Summary of Submissions - Community Submissions - MP09-0039 - 157 Redfern Street, Redfern

Proposed - 21 June 1200
Scale 1:2000

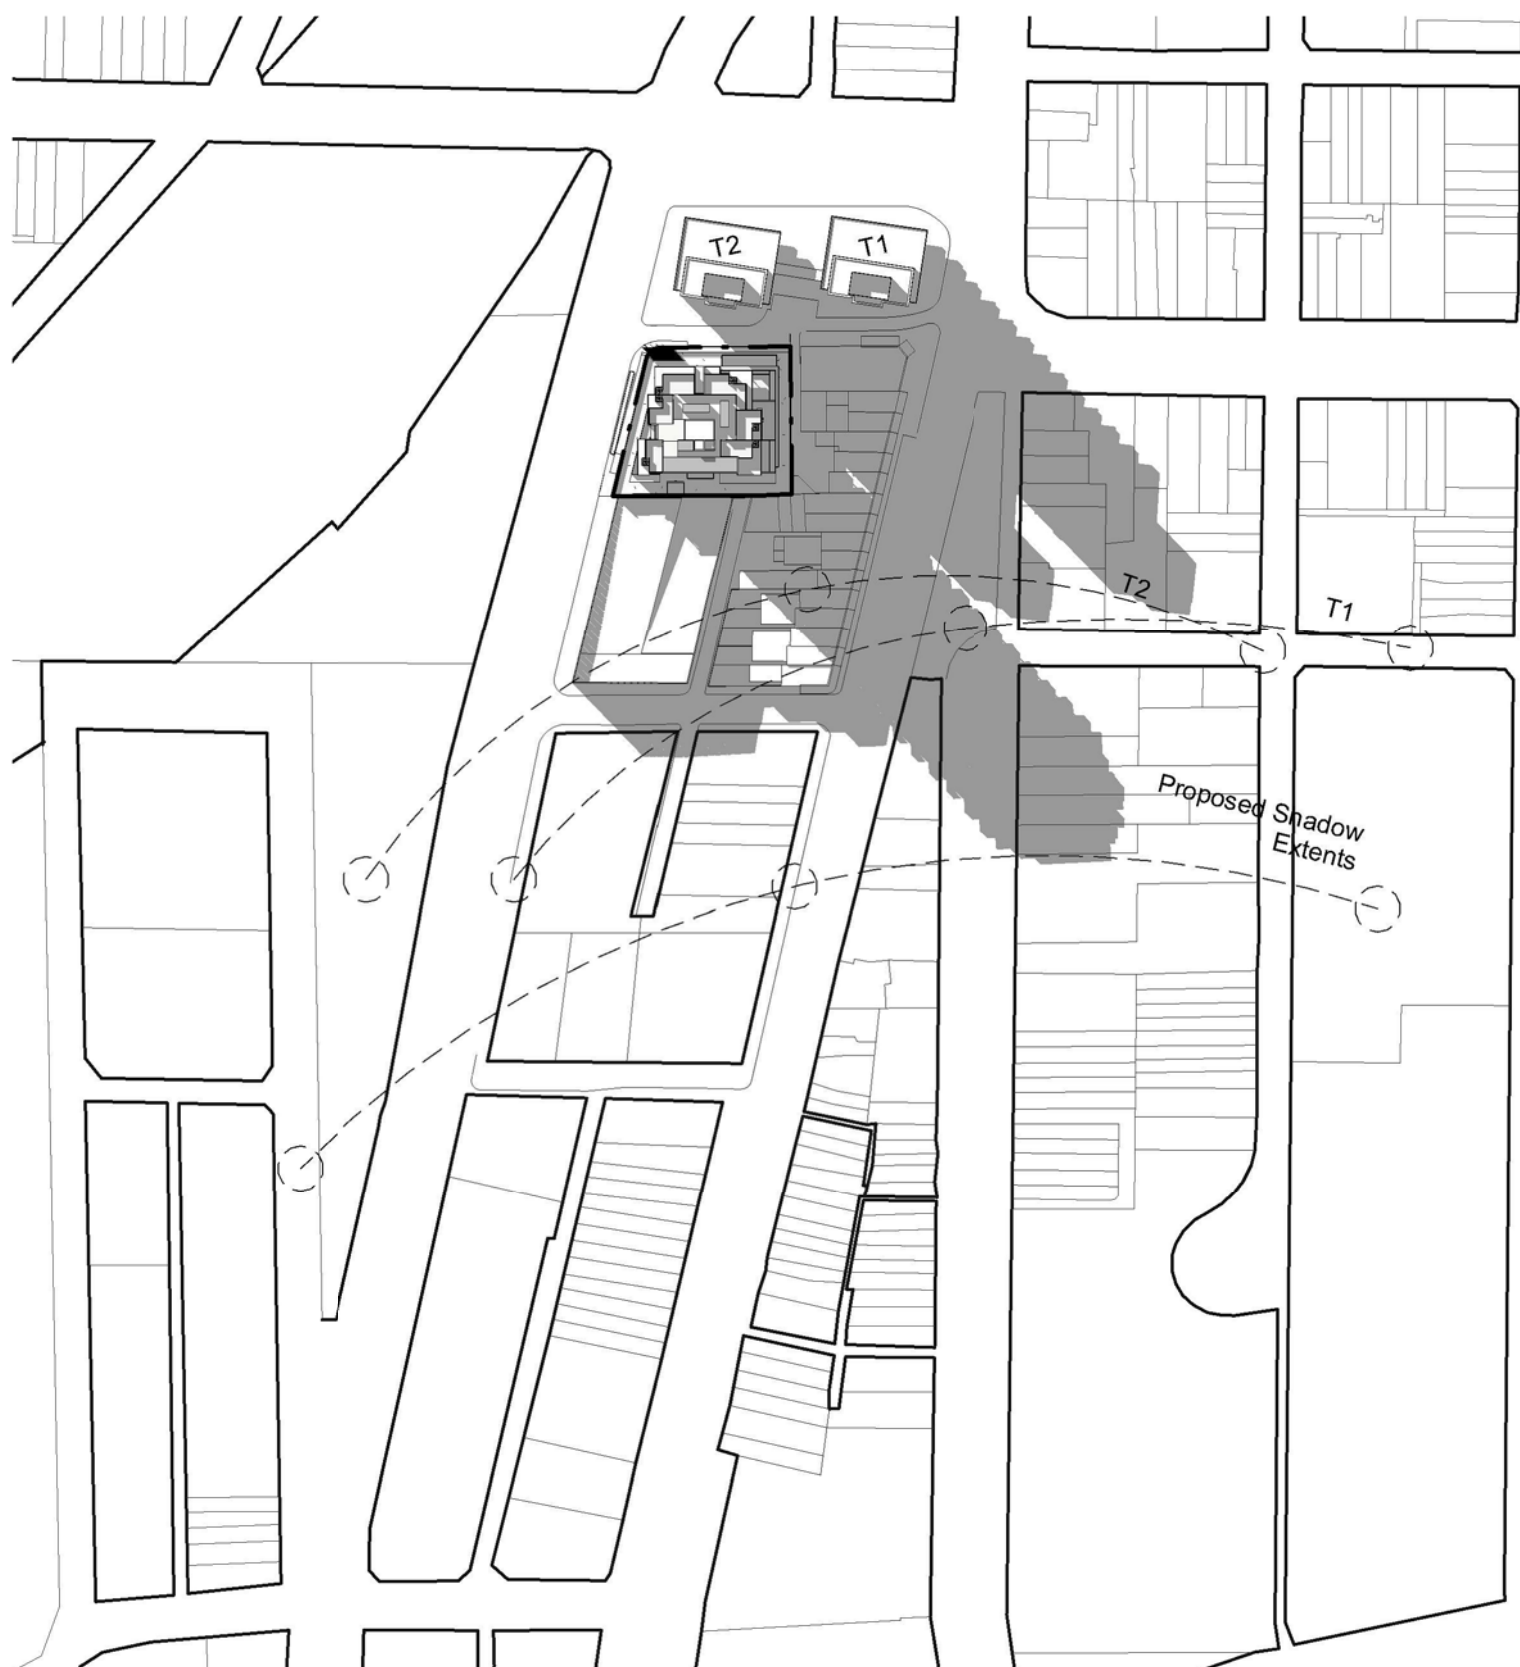
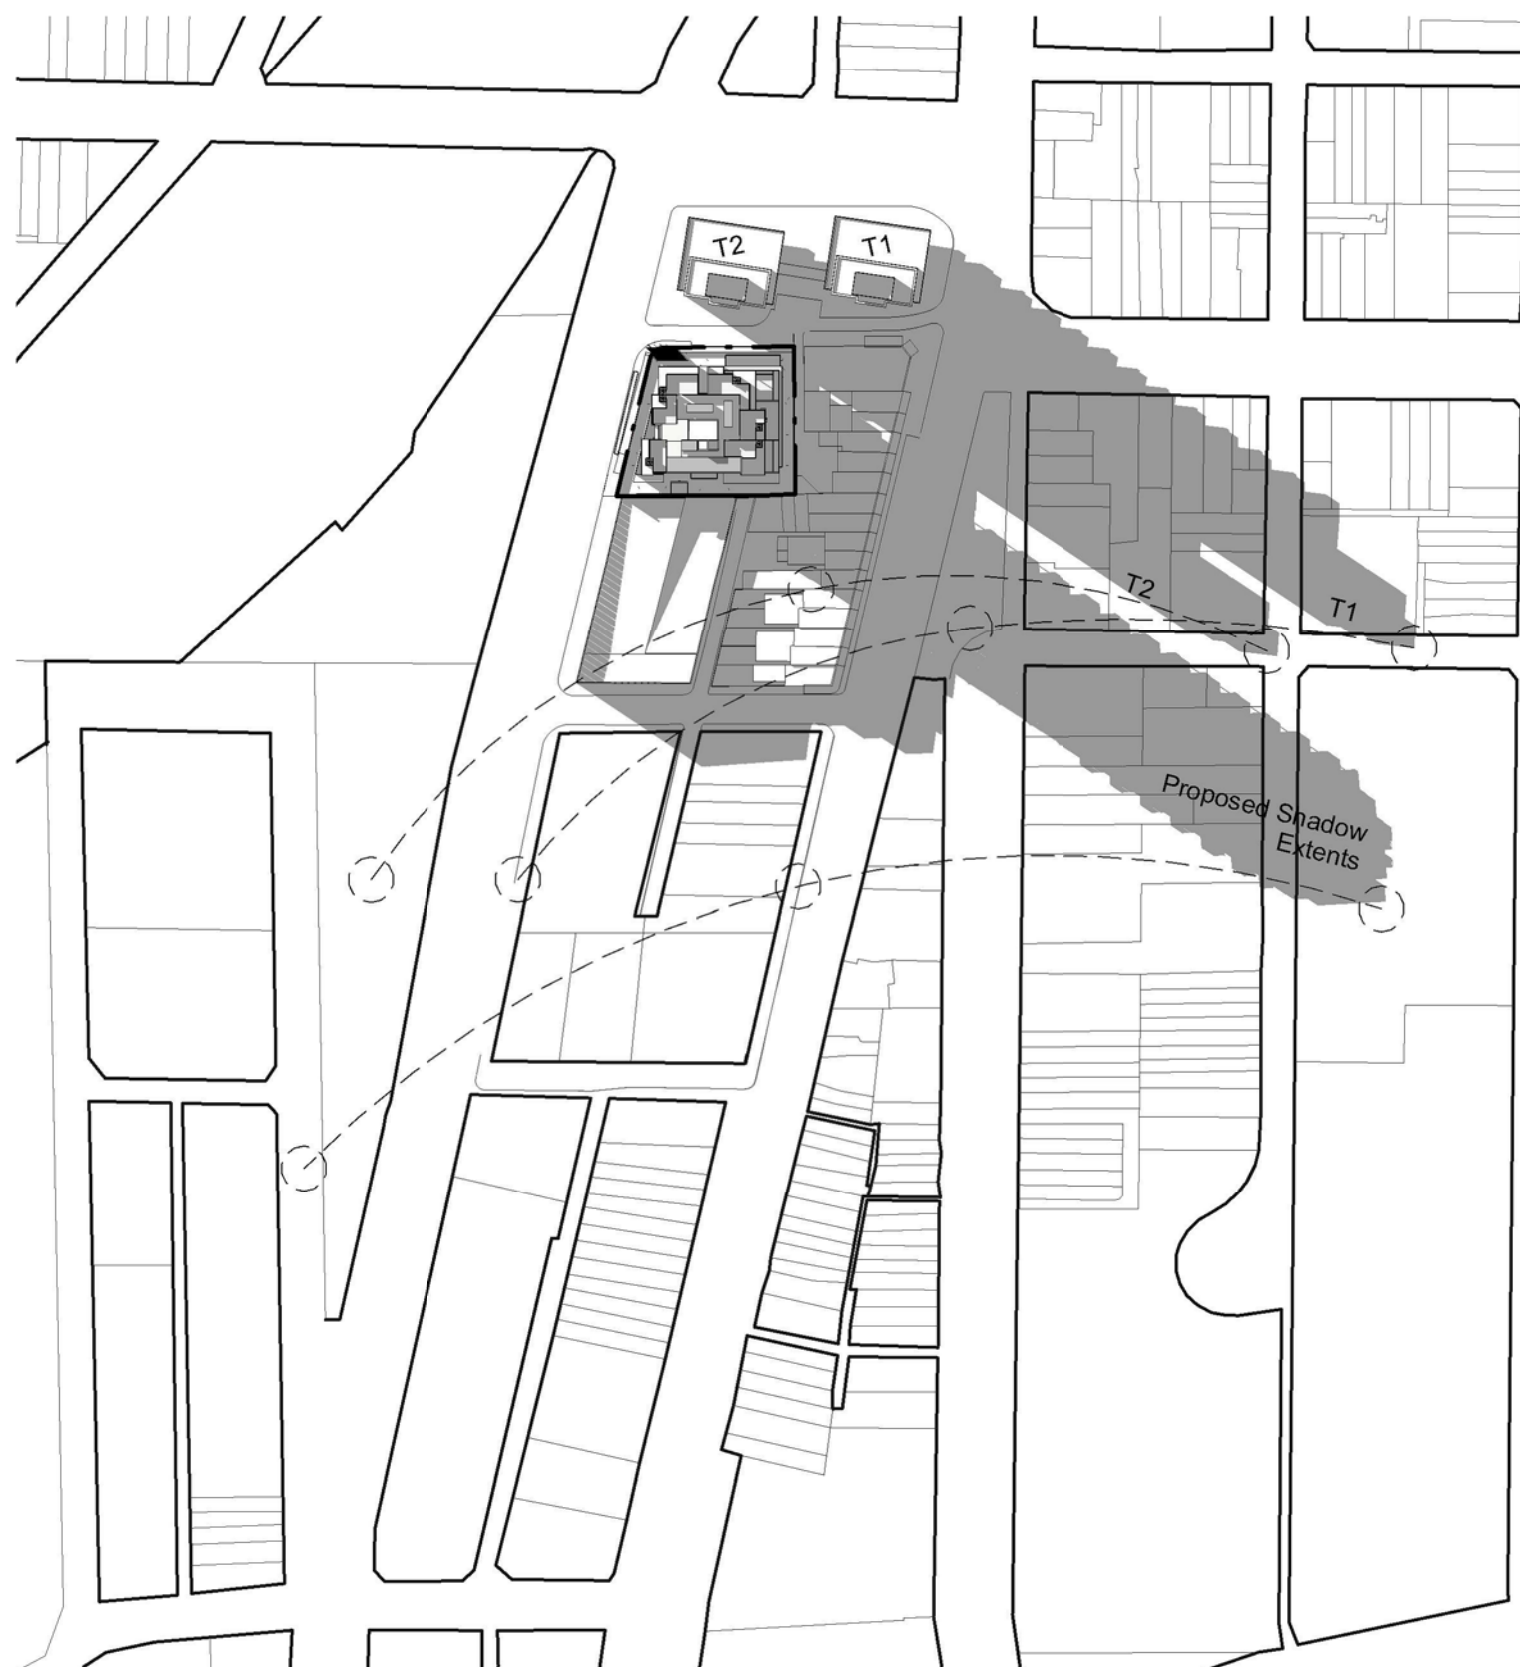
Submittor	Submissions	Response
Kevin O'Sullivan 32/13 Margaret St, Redfern	Objects on the basis: - the height of the building and it being out of character with surrounding development; and - the overshadowing of surrounding development, including 13 Margaret Street	See Sections 3.1.1 and 3.1.12 in Preferred Project Report. Solar access diagrams were submitted with the application. The proposal will marginally overshadow 13 Margaret Street between 9.30am and 10.30am at the winter solstice. This overshadowing will be subsumed by shadows cast by existing and proposed building between the site and 13 Margaret Street.
Scott Goddard 39b Turner St, Redfern	Objects on the basis: - the height of the building; - the overshadowing of surrounding development; and - wind tunnel effects	See Sections 3.1.1, 3.1.9 and 3.1.12 in Preferred Project Report. Solar access diagrams were submitted with the application.

Liza-Mare Syron 24/17 Cope St, Redfern	Objects on the basis: - the height of the building; and - the overshadowing of surrounding development	See Sections 3.1.1 and 3.1.12 in Preferred Project Report. Solar access diagrams were submitted with the application.
Matthew Kennedy 24/13 Margaret St, Redfern	Objects on the basis: - the height of the building; - the overshadowing of balcony and bedroom windows; and - loss of property value	See Sections 3.1.1 and 3.1.12 in Preferred Project Report. Solar access diagrams were submitted with the application. The proposal will marginally overshadow 13 Margaret Street between 9.30am and 10.30am at the winter solstice. This overshadowing will be subsumed by shadows cast by existing and proposed building between the site and 13 Margaret Street.
